RE: Development Submission D/2017/349, 201 Elizabeth Street, Sydney

I wish to advise that I am an Executive Member of the Owners Corporation SP 3397 which represents the owners and occupiers of 27 Park Street, Sydney, known as Park Regis a 45-level residential/hotel tower and historic building.

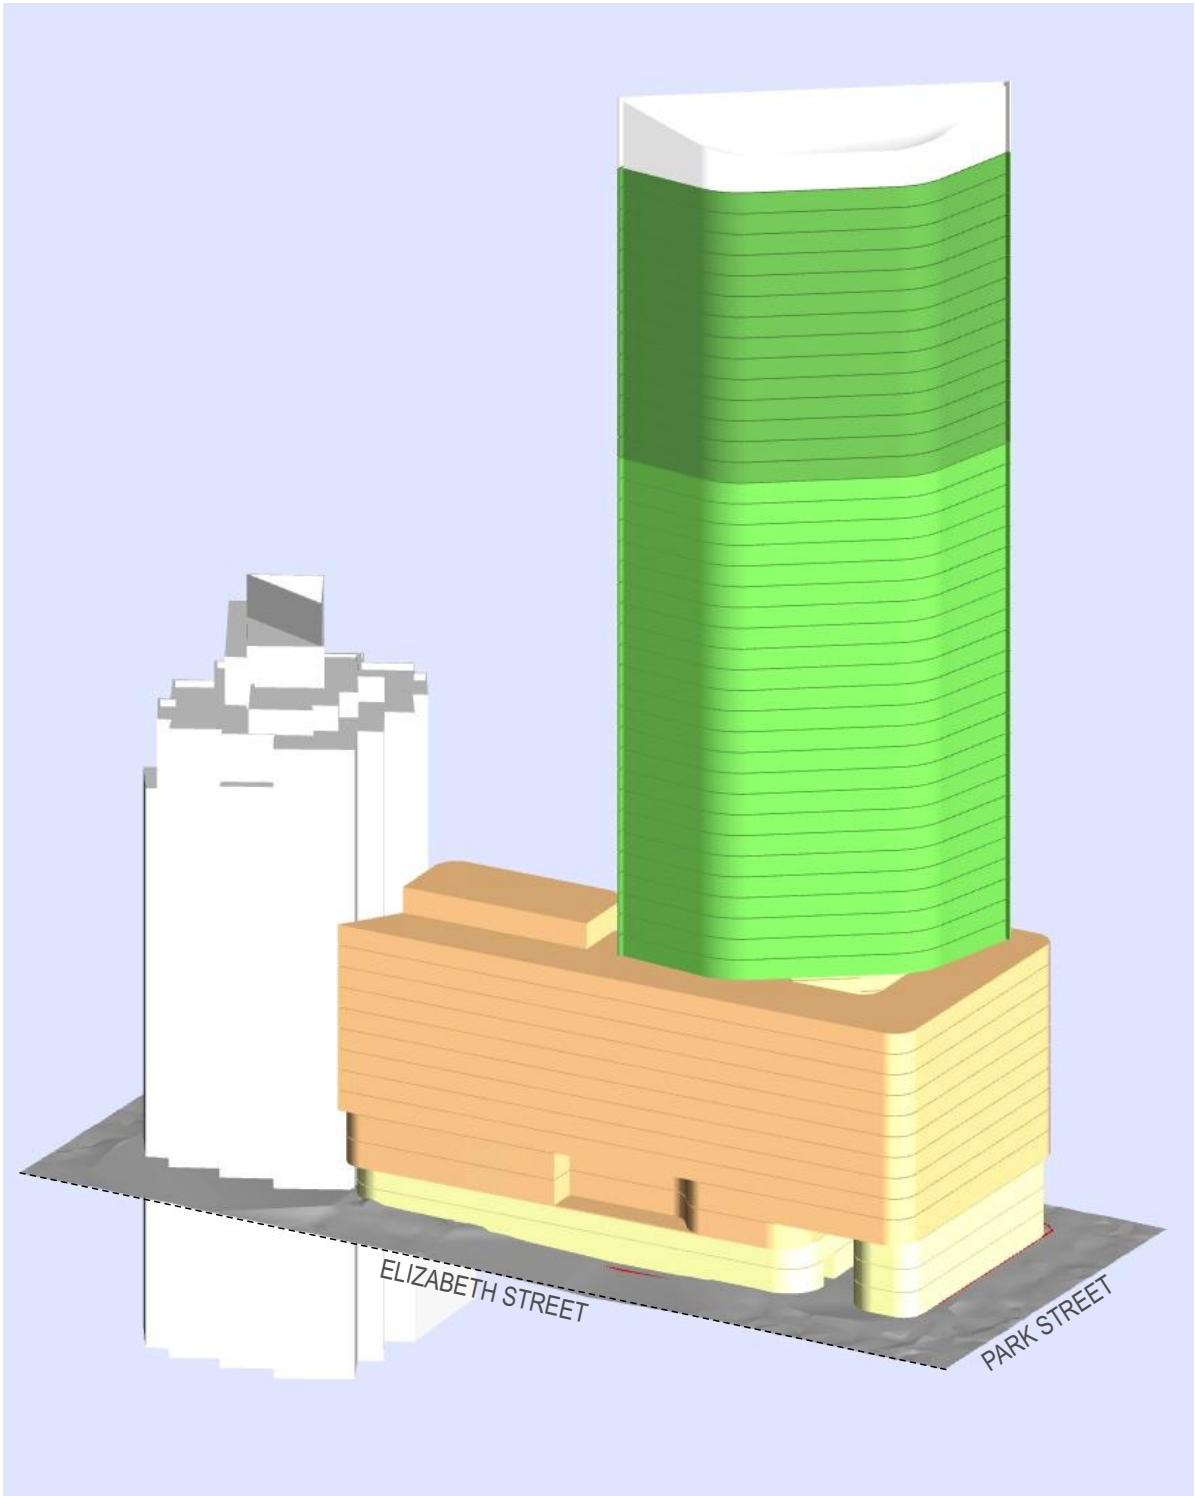
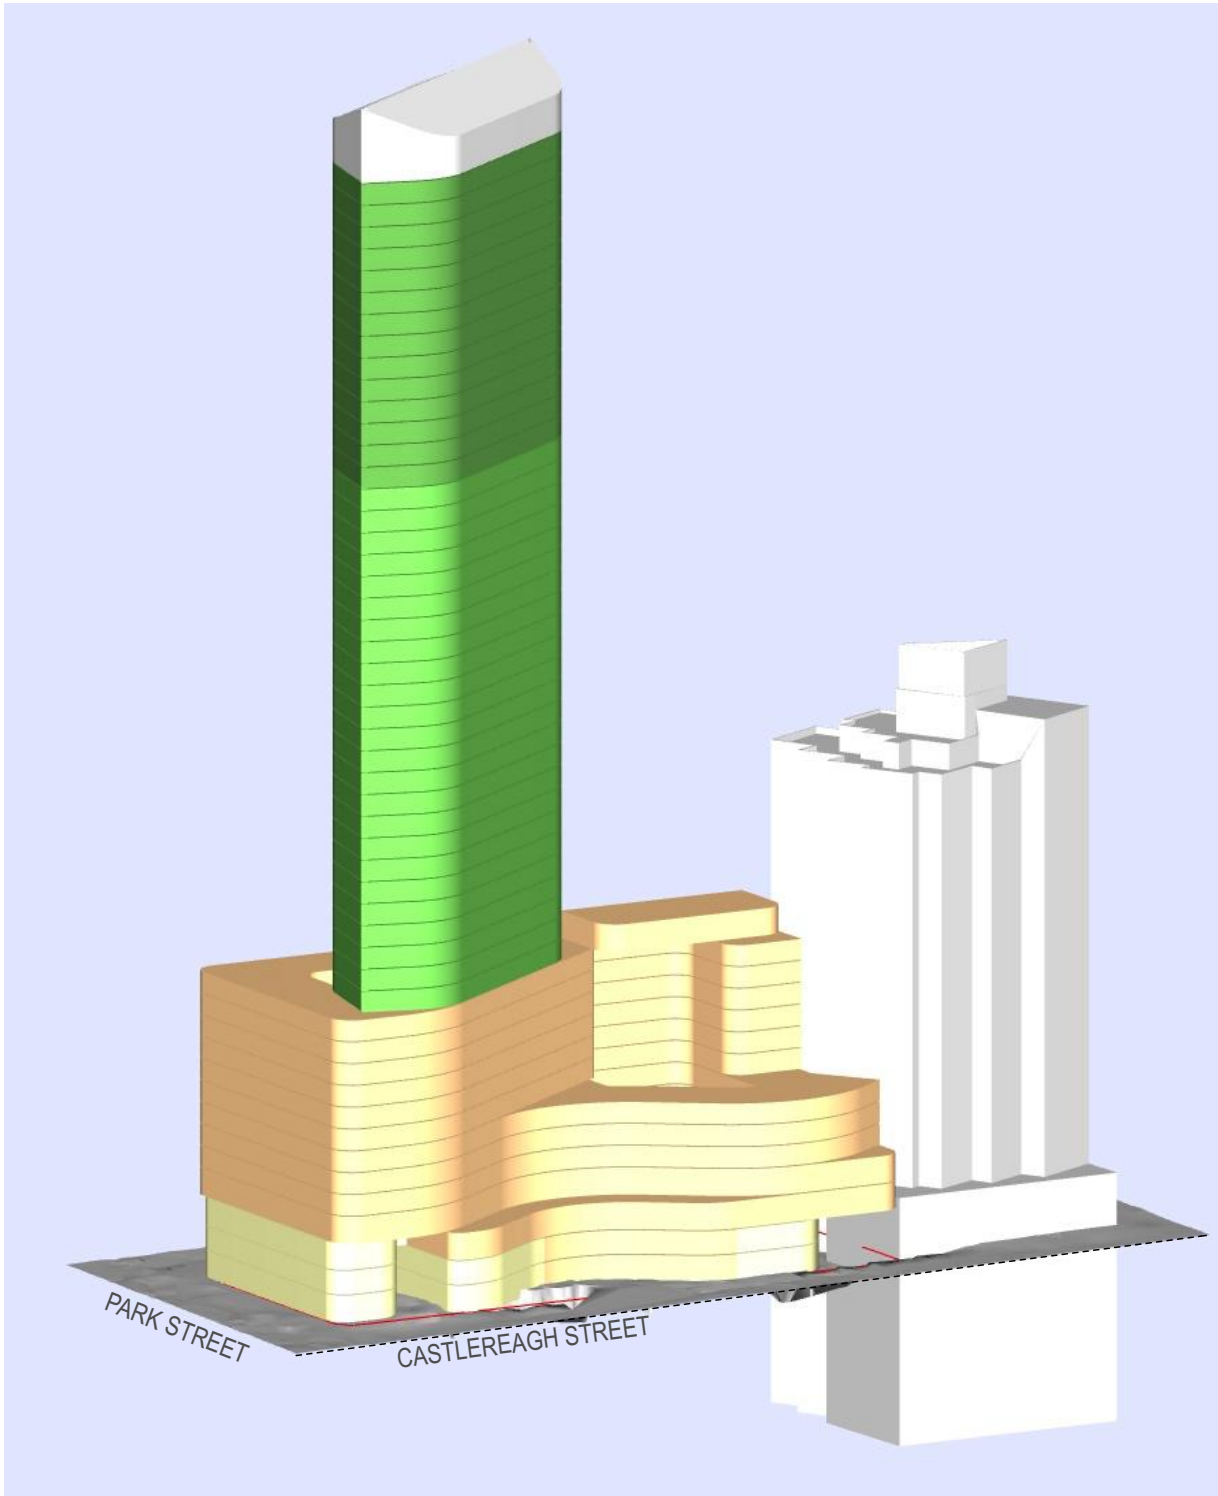
There appears to be no reason to move the residential tower close to Park Street other than to cause substantial negative effects to those existing owners.

The move of the tower towards Park Street has an unnecessary and magnified effect on view loss for existing developments. Those existing developments whose views are impacted by the present tower have purchased their unit mindful of the view impact. To relocate the tower and increase its size will adversely impact the view down Park Street which are presently enjoyed to solely to the current building's position. Undoubtedly this was the reason for the initial set-back when the building was constructed.

To allow the tower to be moved towards Park Street or increase in size will devalue the gateway principle and block the broad view to the historic Town Hall building.

Hyde Park - Overshadowing Analysis | Annual Shadow Study

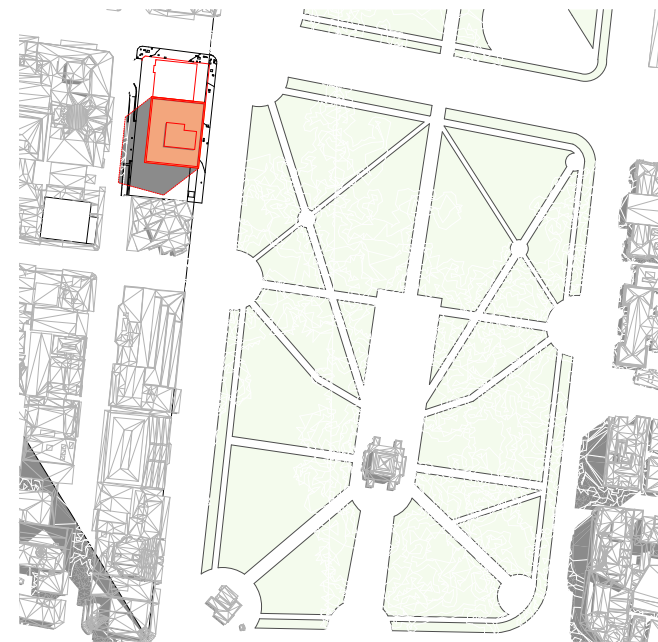
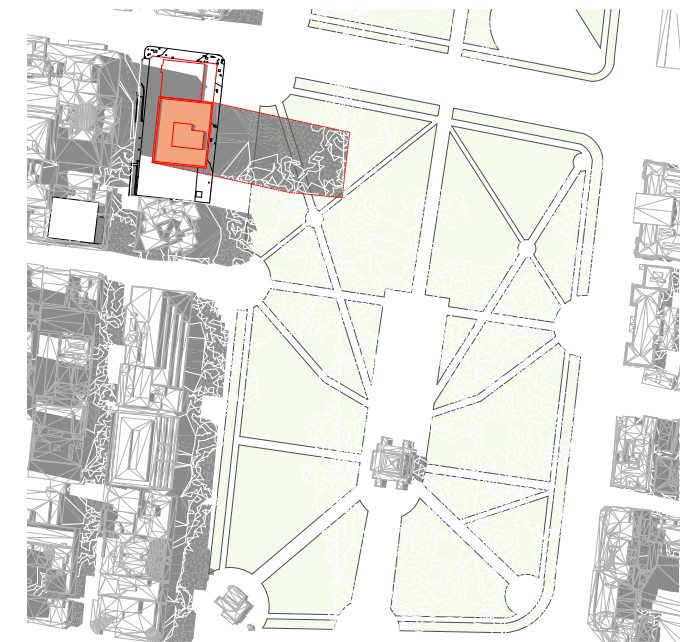
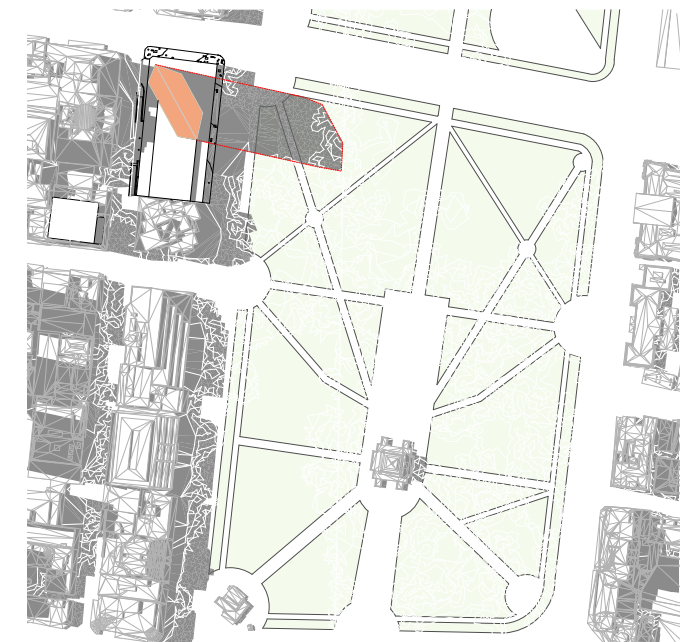
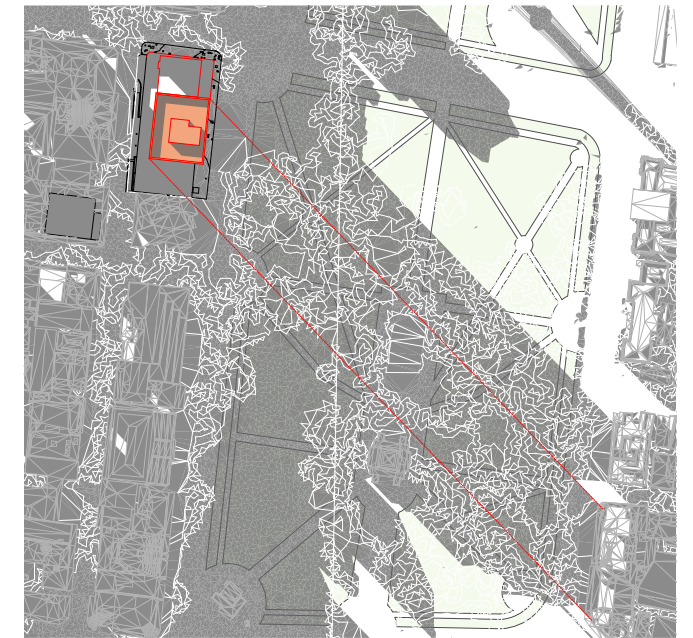
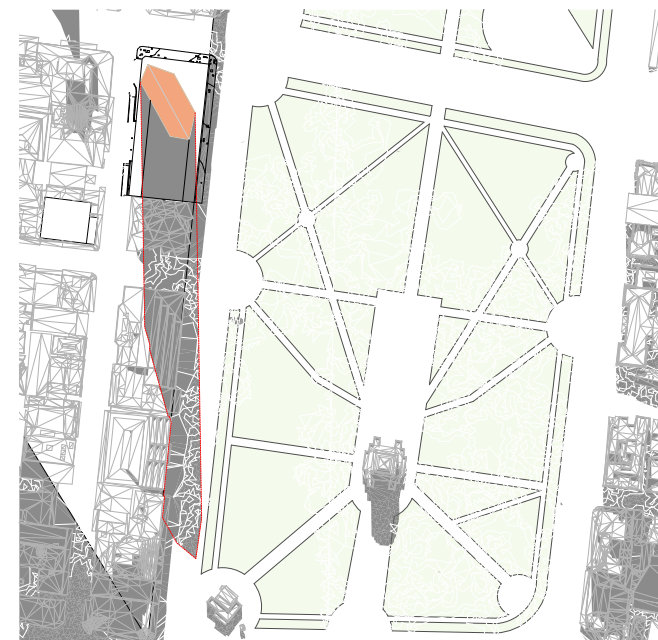
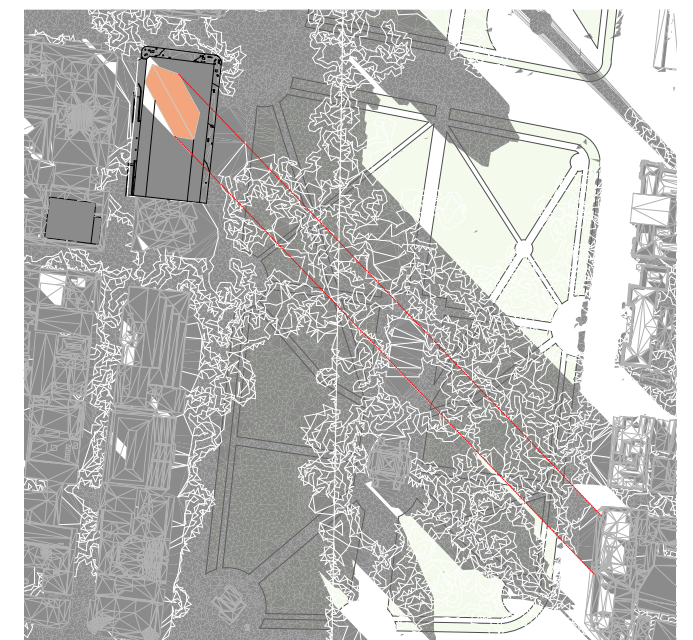
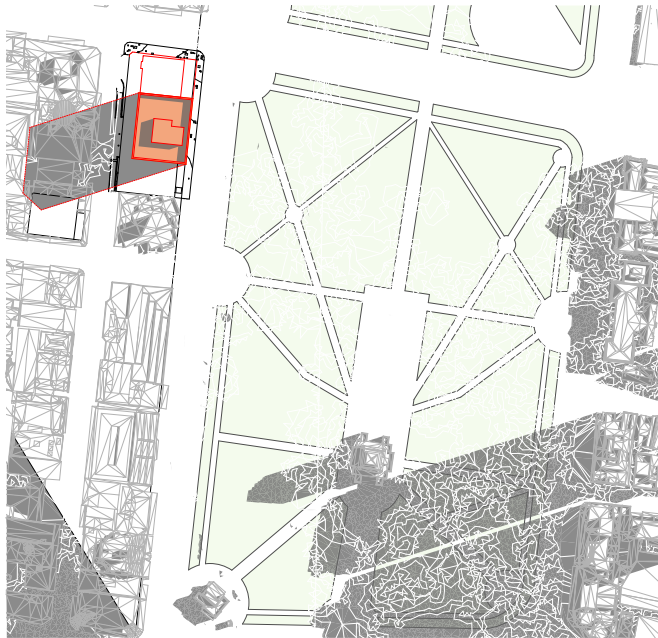
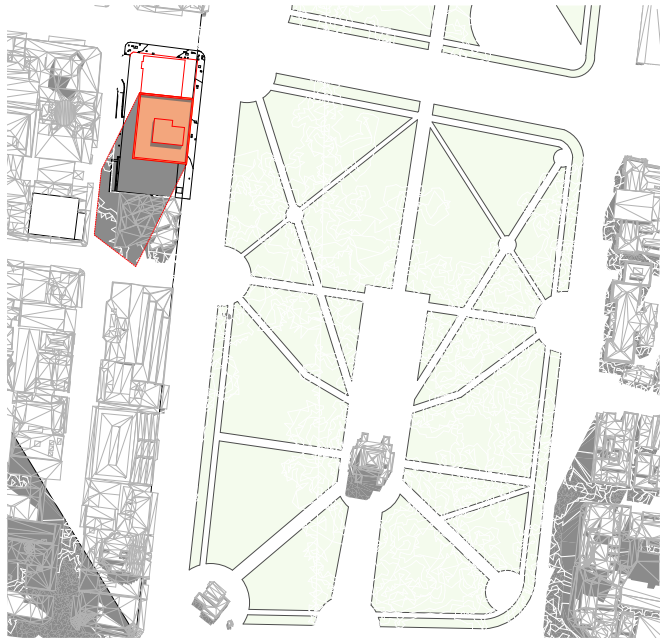
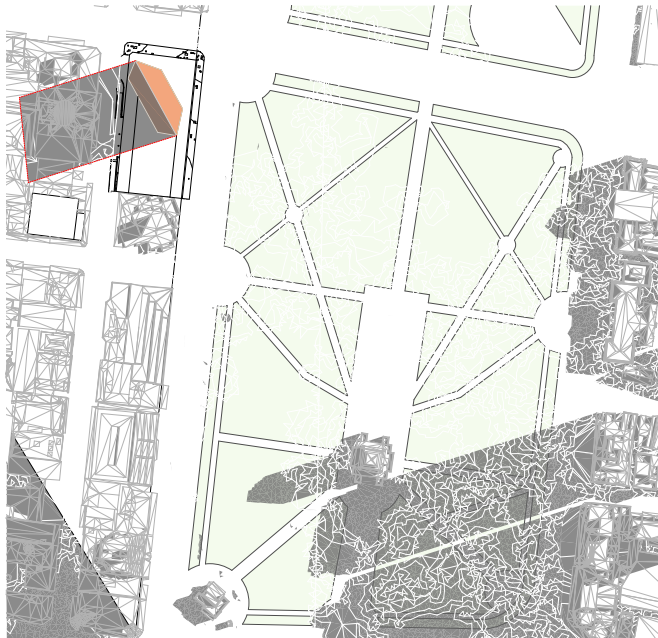
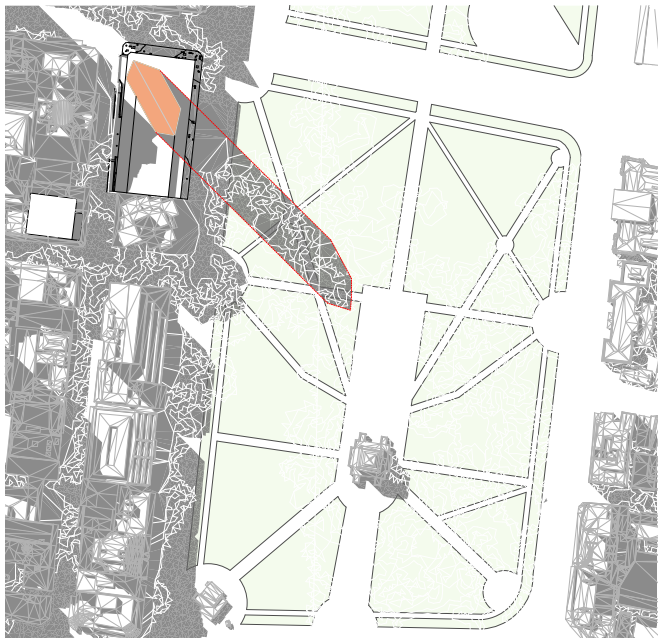
It appears that this is a gross development of the site with a structure which is unnecessarily high and bulky. It will further impact by shadowing Hyde Park and reducing light to properties along Castlereagh Street.
